Holbeach Road, Spalding

Highways Technical Note

Response to Highways Comments from Lincolnshire County Council

Planning Application Reference: 25/0704/FUL

Appendix C
Proposed Site Access Design, Visibility
Splays and Tracking

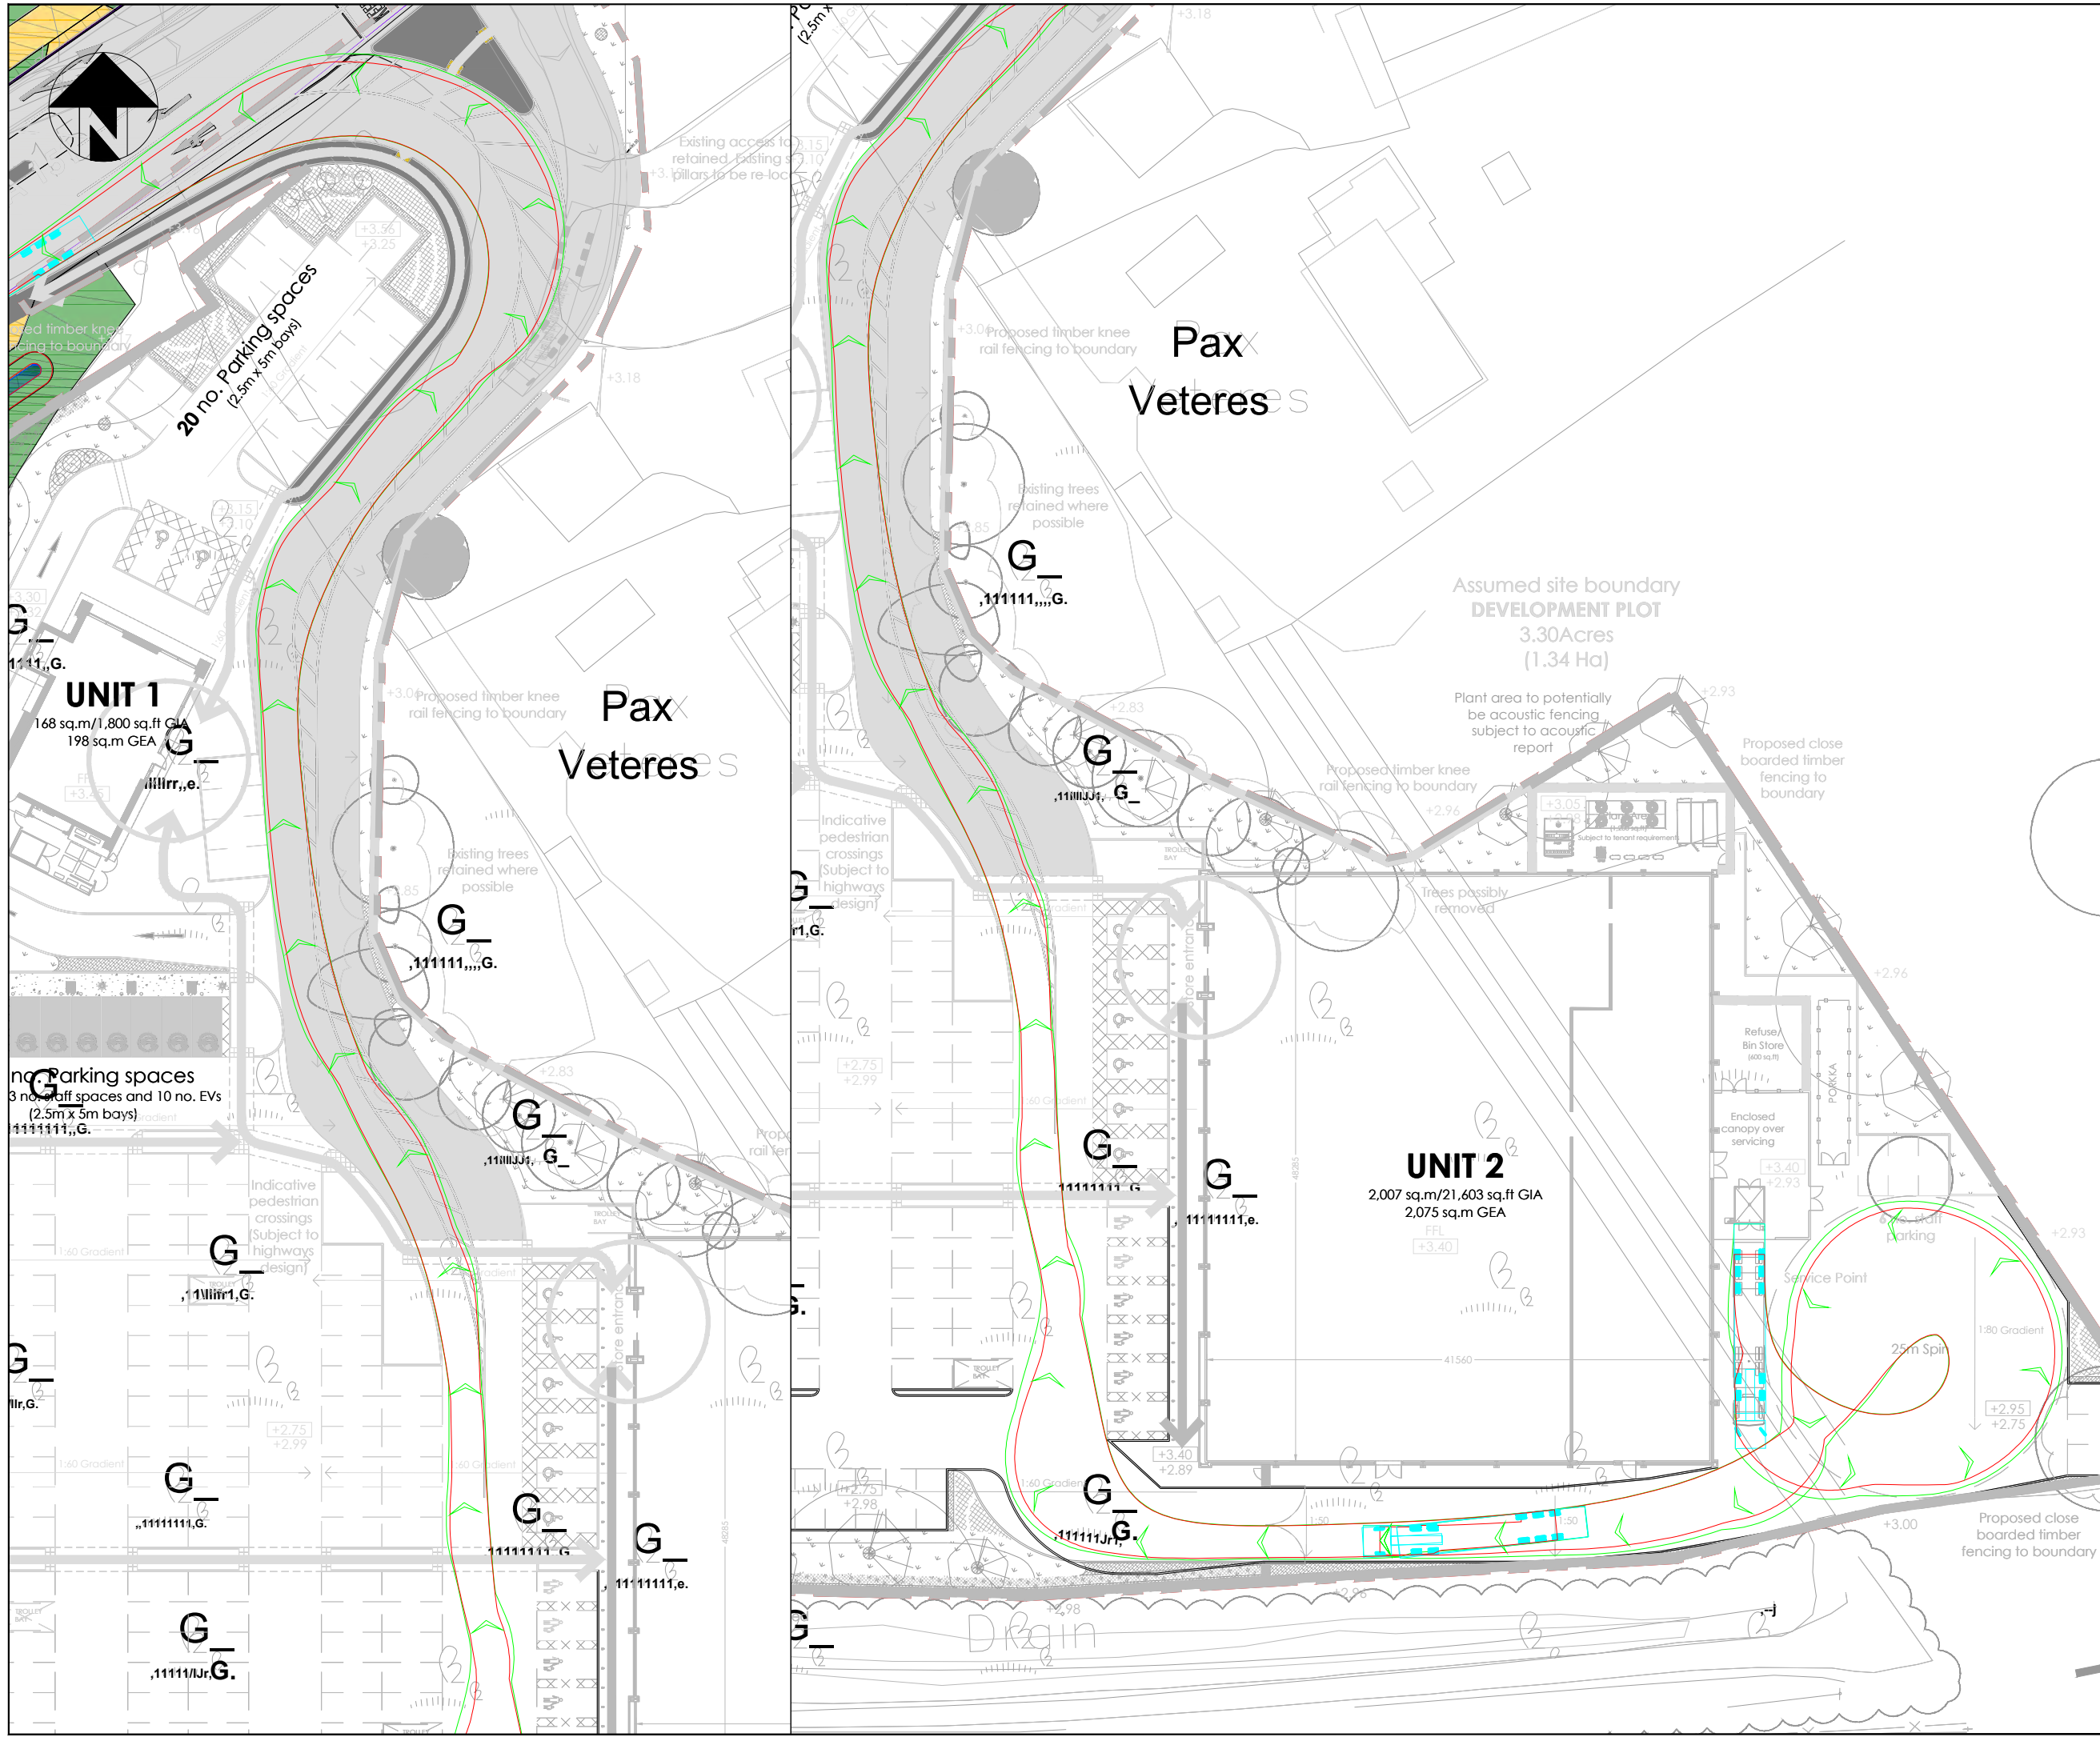
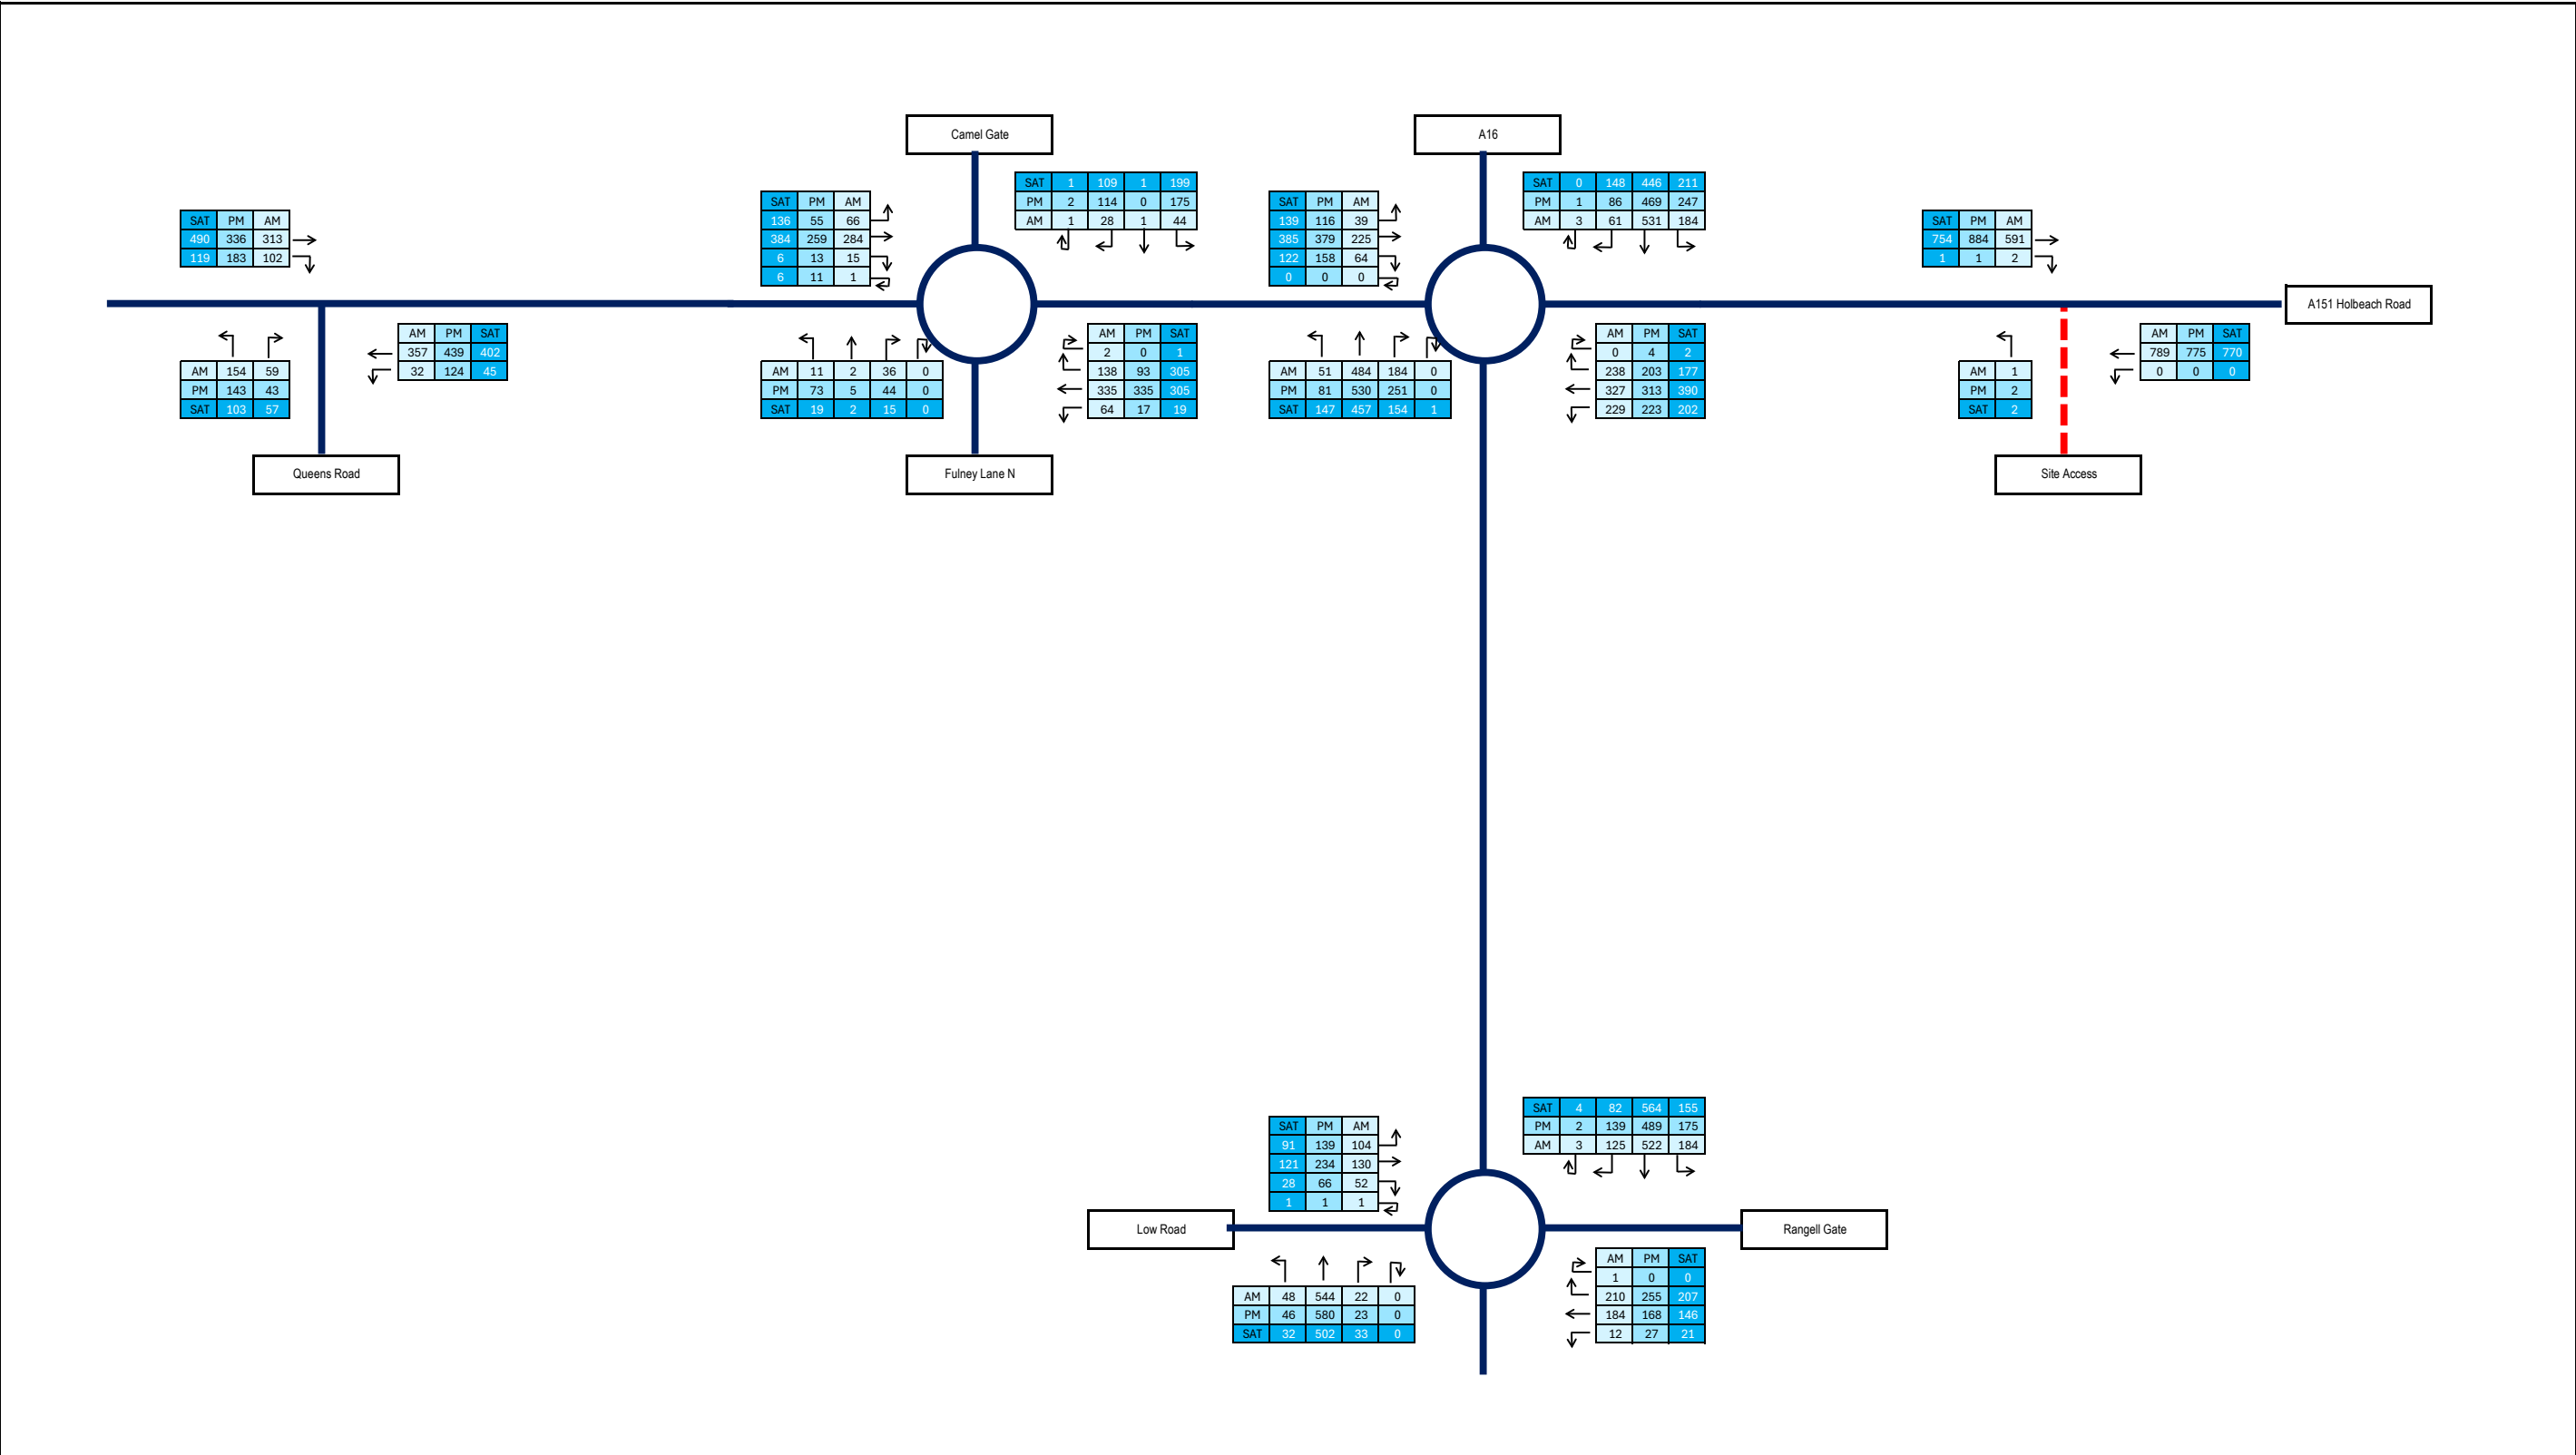
We have significant concerns about the access arrangements. Pre app discussions were based on different access arrangements.

The A16 roundabout improvement scheme designed Ghost Island Right Turn Lane for residential use and is as existing. It is not built to DMRB standard. Stacking is not available for service vehicles expected to visit the site. There is the potential for vehicles to back up over the roundabout - capacity concerns.

There is significant highway signage that will need moving to accommodate the access – this has not been addressed and relocation details provided. The street lighting may also need moving.

The tracking is unworkable at peak hours as HGV's will need to take up both lanes exiting the site. The swing that is needed can't be achieved on the access road without moving the stone pillars – we need security that they can be moved.

While it is noted that the access junction doesn't comply with DMRB in terms of the length of the ghost island right-turn facility, it is still considered acceptable in this location. This is due to the proximity of the site access junction to Springfield Roundabout. A 50m ghost island right-turn facility is typically required on a 40mph road which is required for deceleration. Drivers entering the right-turn ghost island facility in this location will be exiting Springfield Roundabout, therefore, a 50m length is not required. A 38m ghost island facility in this location is considered appropriate given that it's similar to the 35m requirement for a 30mph speed limit. Vehicles exiting Springfield Roundabout onto the A151 Holbeach Road are likely to be travelling at 30mph before accelerating towards the 40mph speed limit as they continue north-eastbound on the A151 Holbeach Road.

In terms of stacking spaces for a HGV waiting to turn right into the site, 38m is more than sufficient given that a max legal articulated HGV is 16.5m long.

Items such as relocating signage and street lighting can be dealt with at the detailed design stage.

The site will have a delivery strategy in place that ensures that HGVs arrive outside of the peak periods. The stone pillars will be removed / relocated as they conflict with the eastern carriageway edge of the proposed site access road.
